CITY OF ALBUQUERQUE

May 15, 2018

Re: Sandia Acrobatic Gymnastics Academy, 3400 Candelaria Rd NE
Request for Certificate of Occupancy
Transportation Development Final Inspection
Architect's Stamp dated 09-29-17 (H16-D152)
Certification dated 05-10-18

**TCL**  
TRAFFIC CIRCULATION  
PLAN

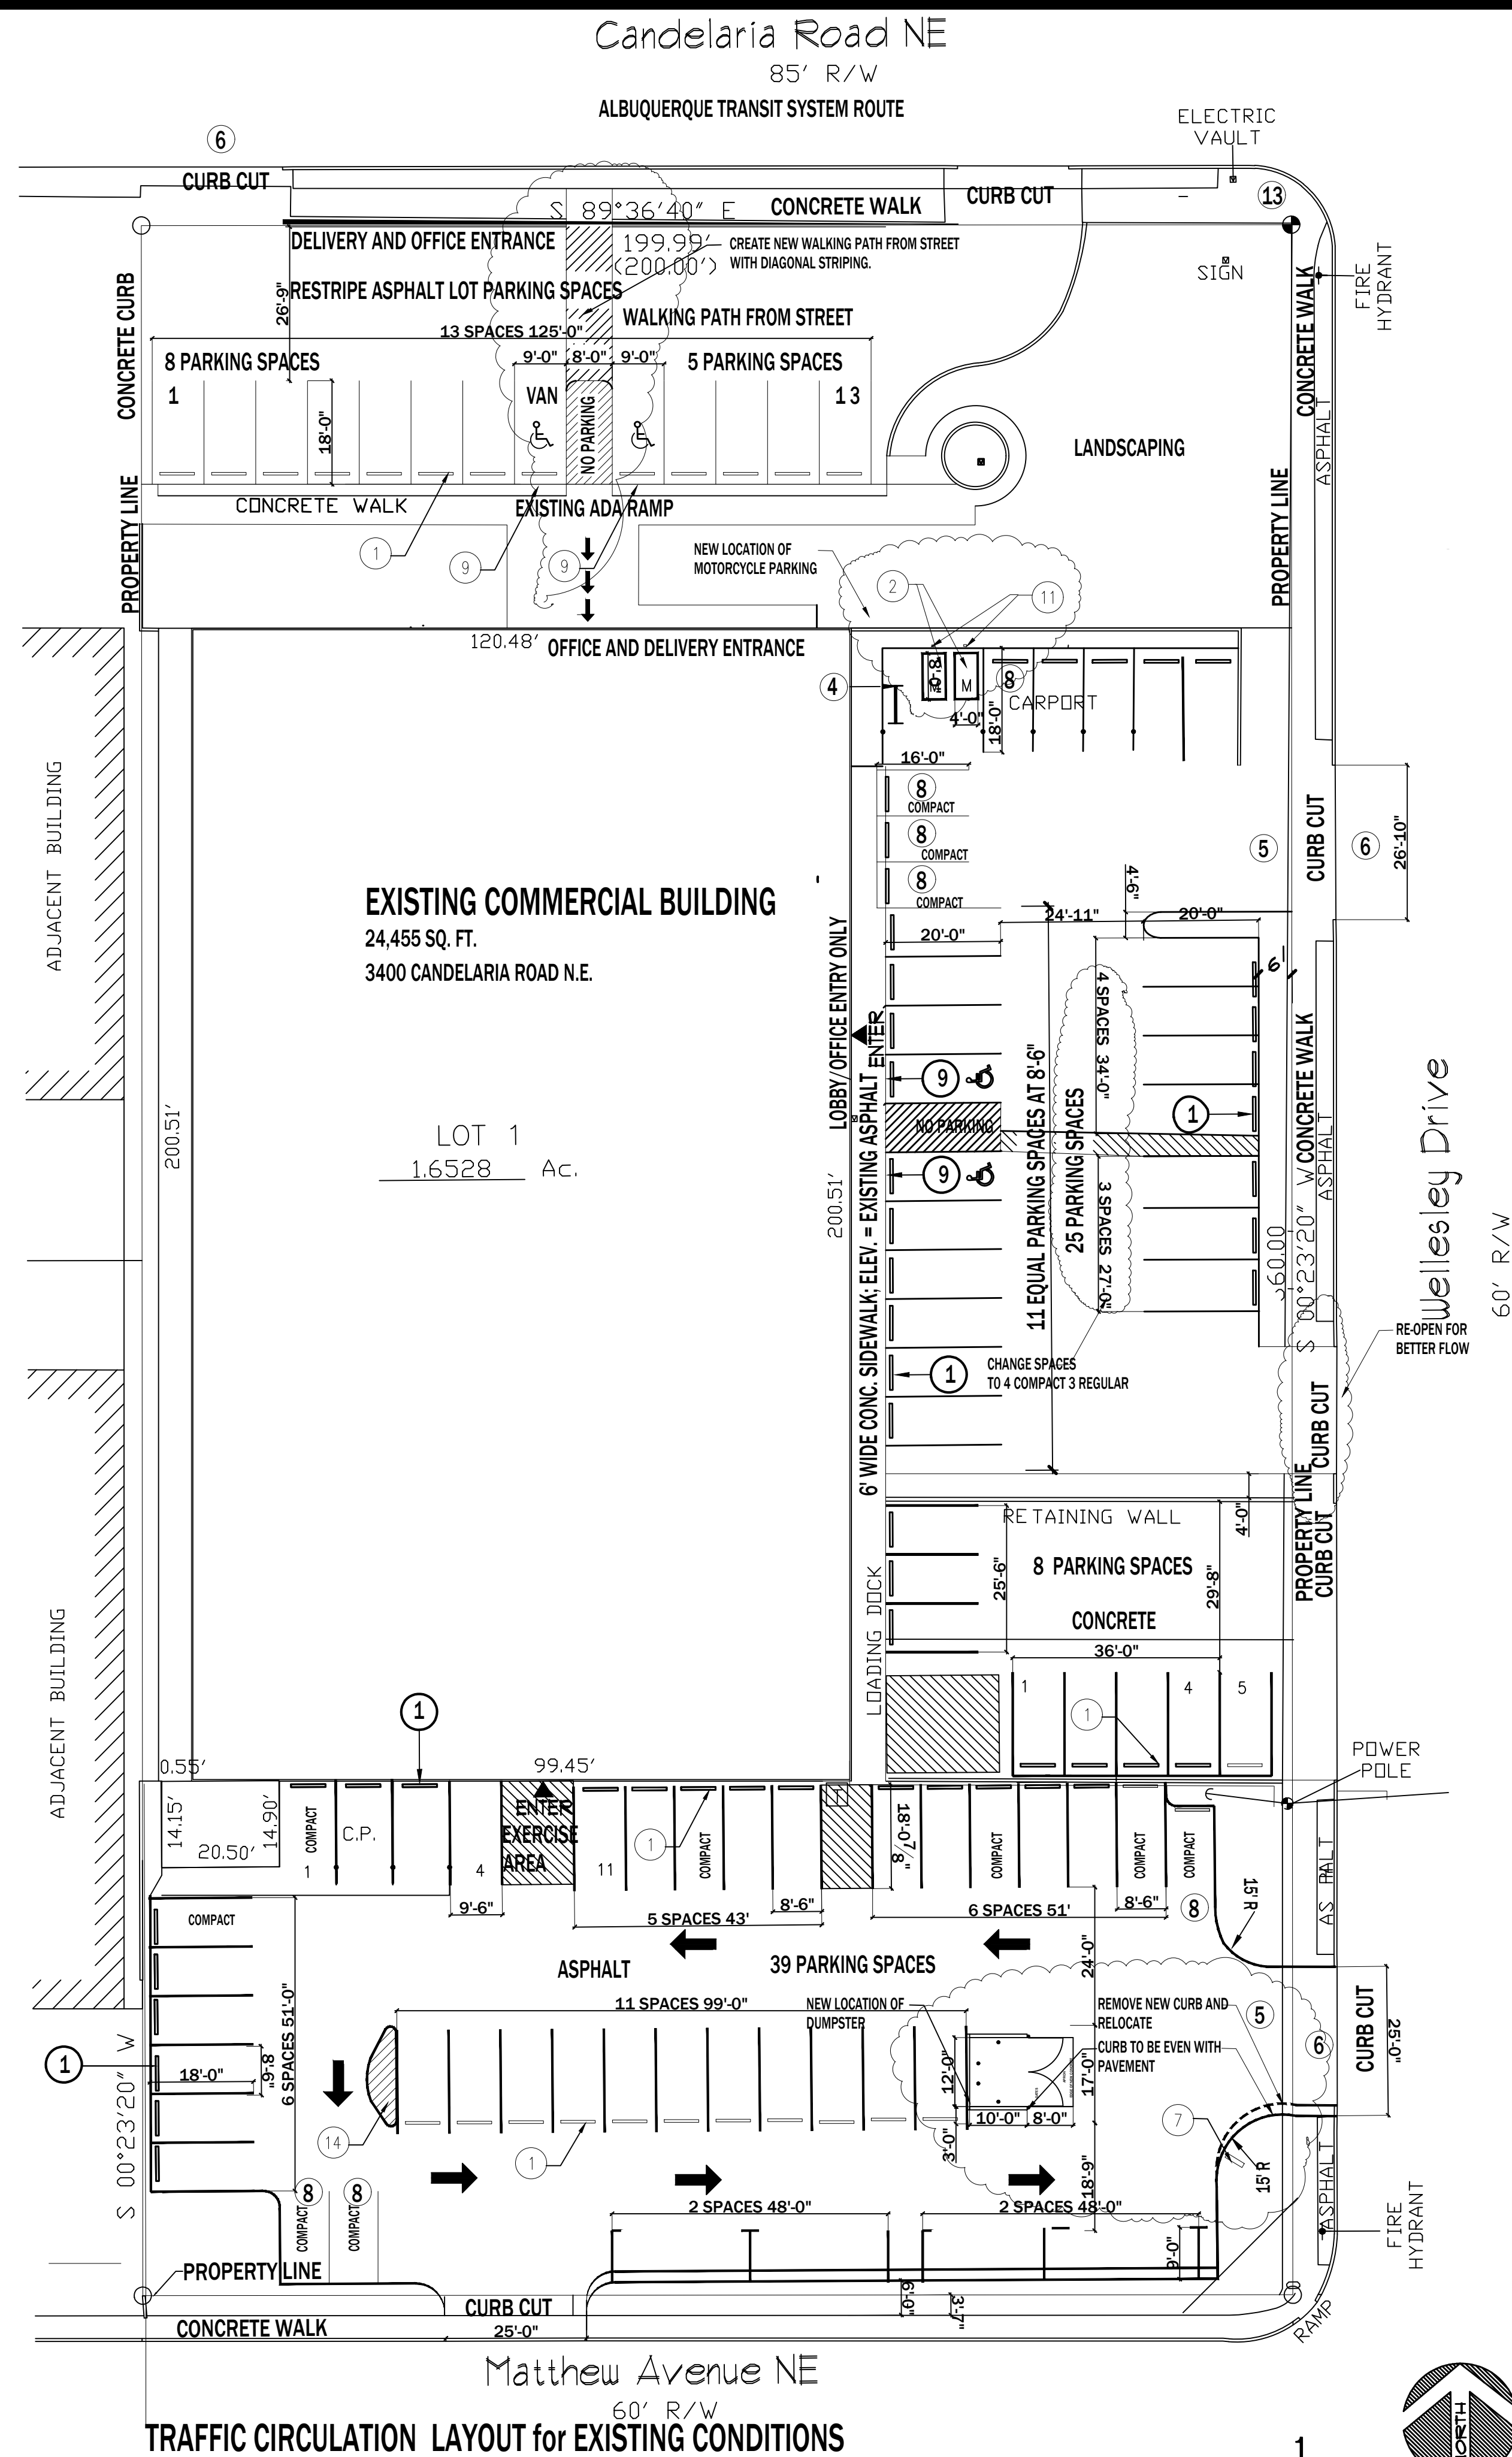
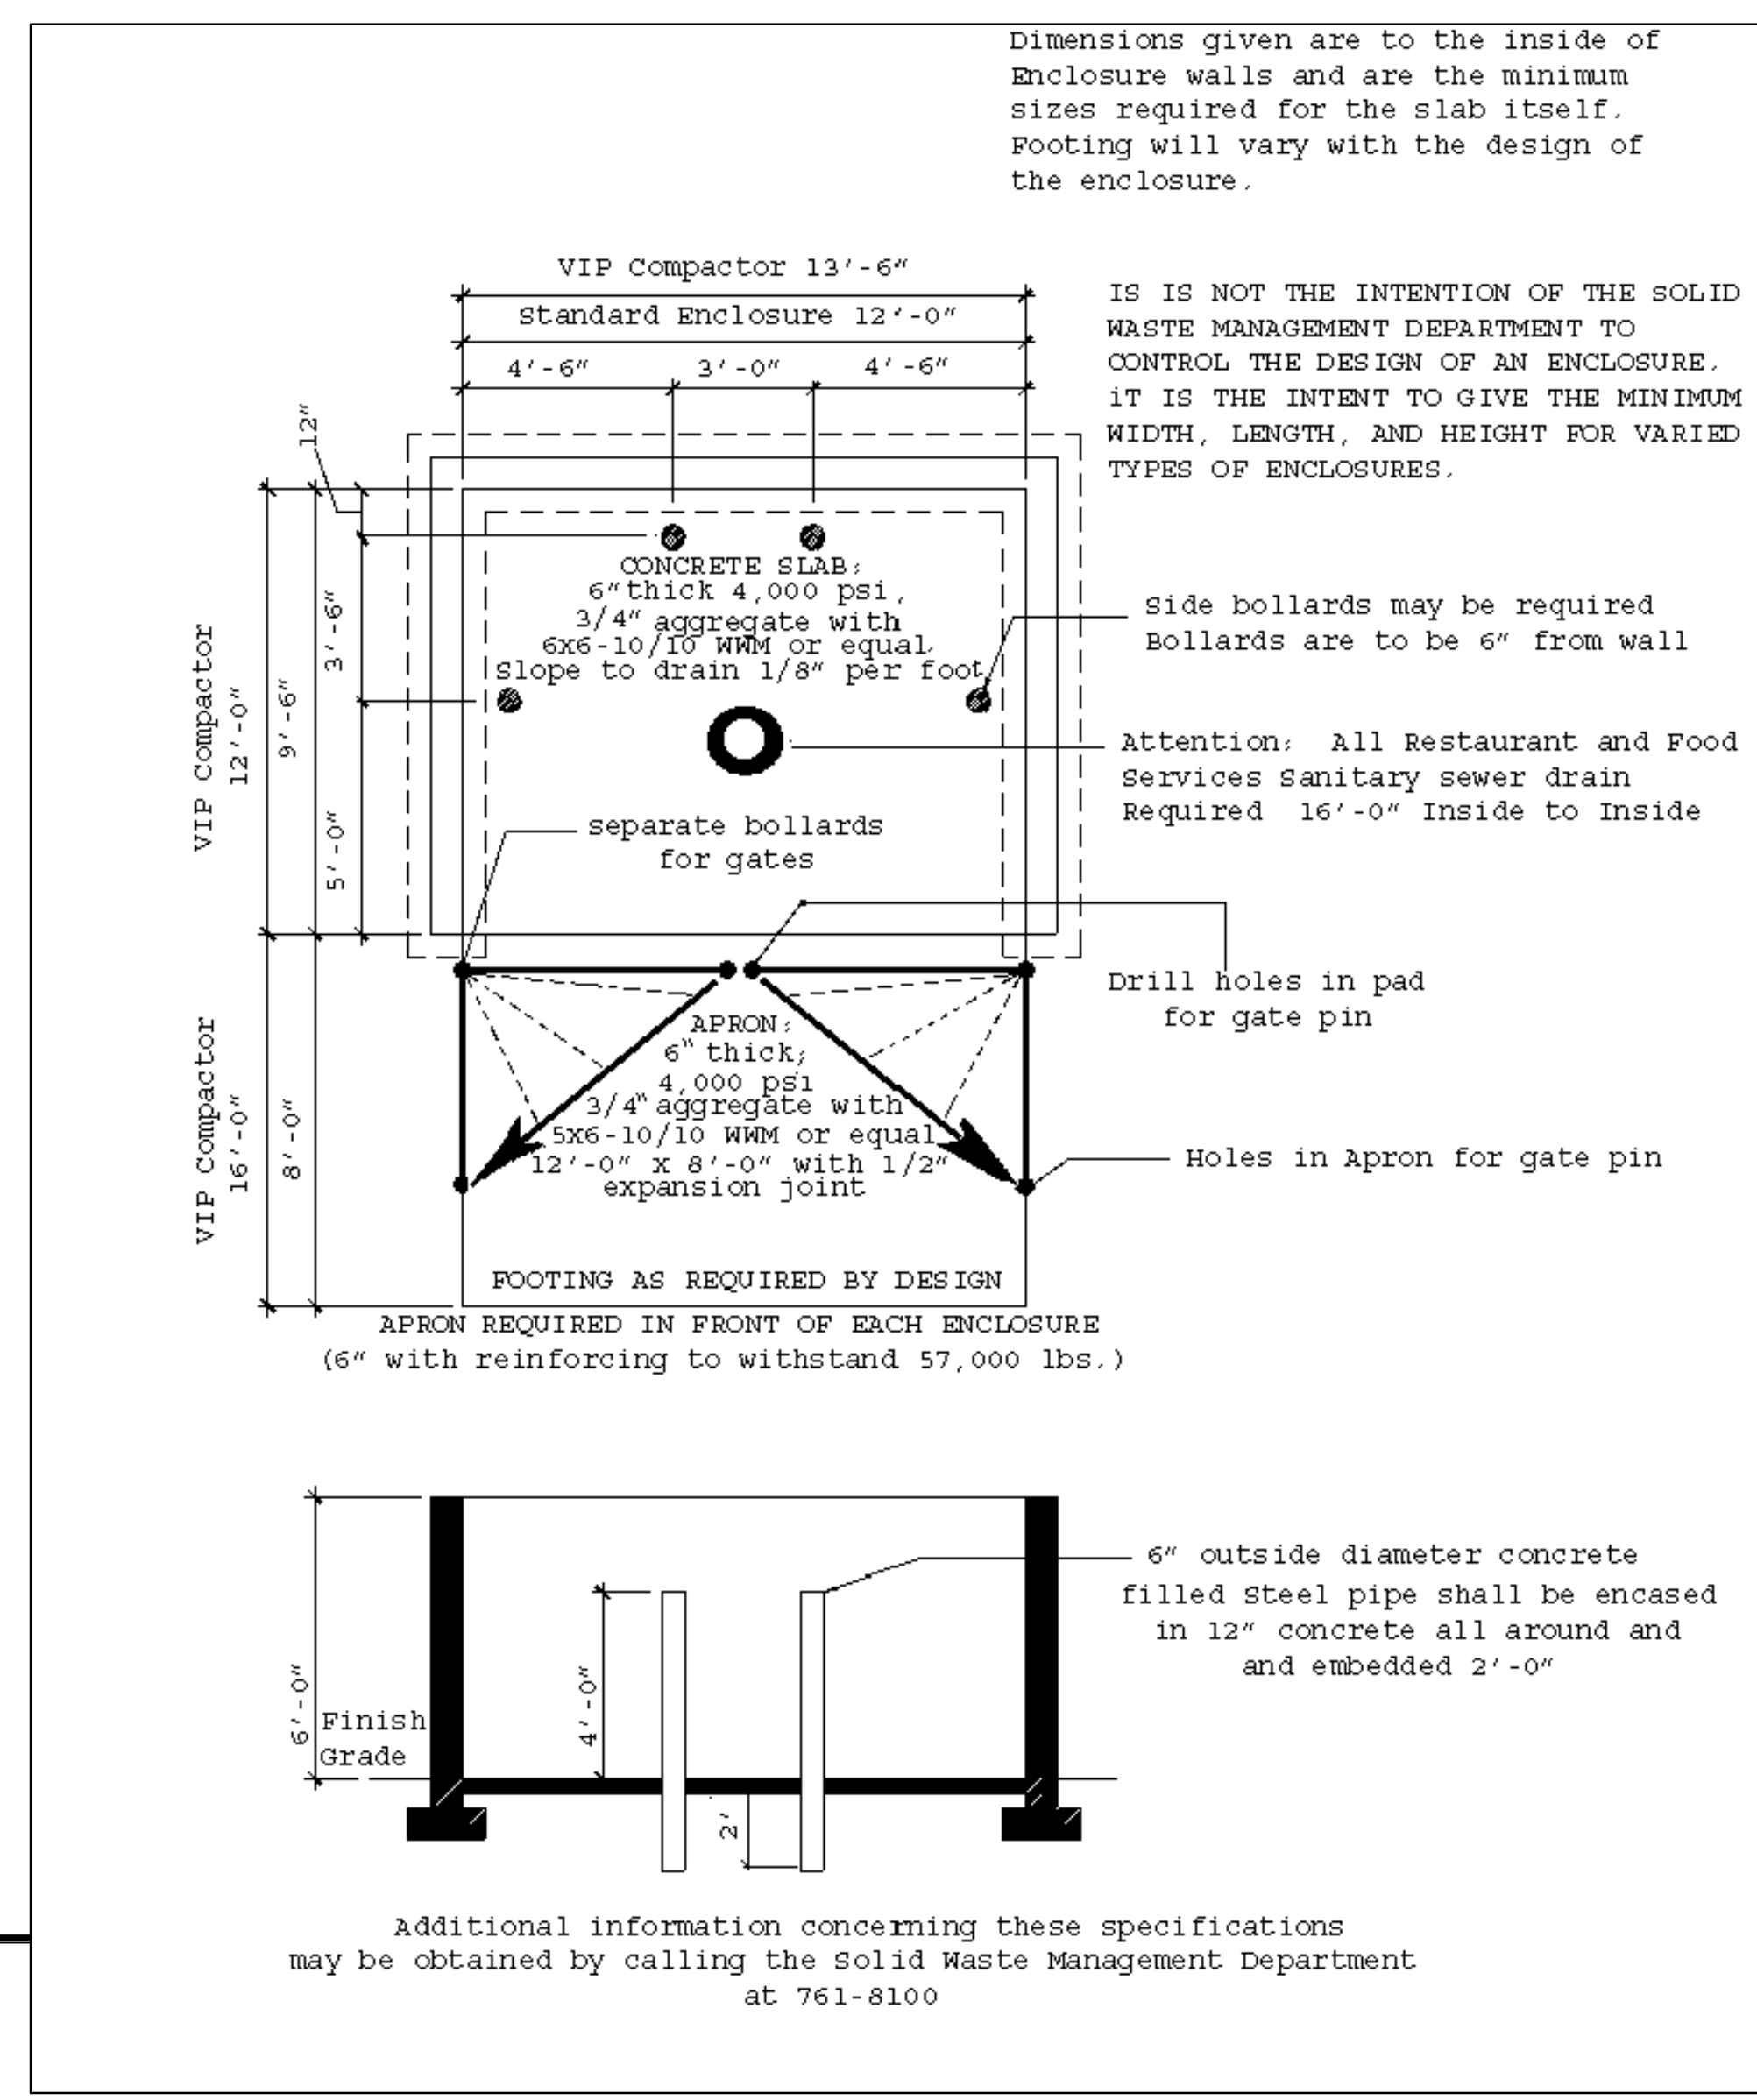
- Compact spaces must have the word "**COMPACT**" on the pavement of each space.
- The ADA accessible parking sign must have the required language per 66-7-352.4C NMSA 1978 "**Violators Are Subject to a Fine and/or Towing.**"
- Directional arrows and/or "**one way**" signs are required for one way traffic aisle. They are missing on the south lot.
- Unused curb cuts must be closed with curb, gutter and sidewalk.
- The parking spaces located in the loading dock are not striped correctly.
- The ADA Curb Ramp at the corner of the property was not addressed.
- The ADA connection to the front of the building from the Right of Way is not ADA compliant. The grades are too large.
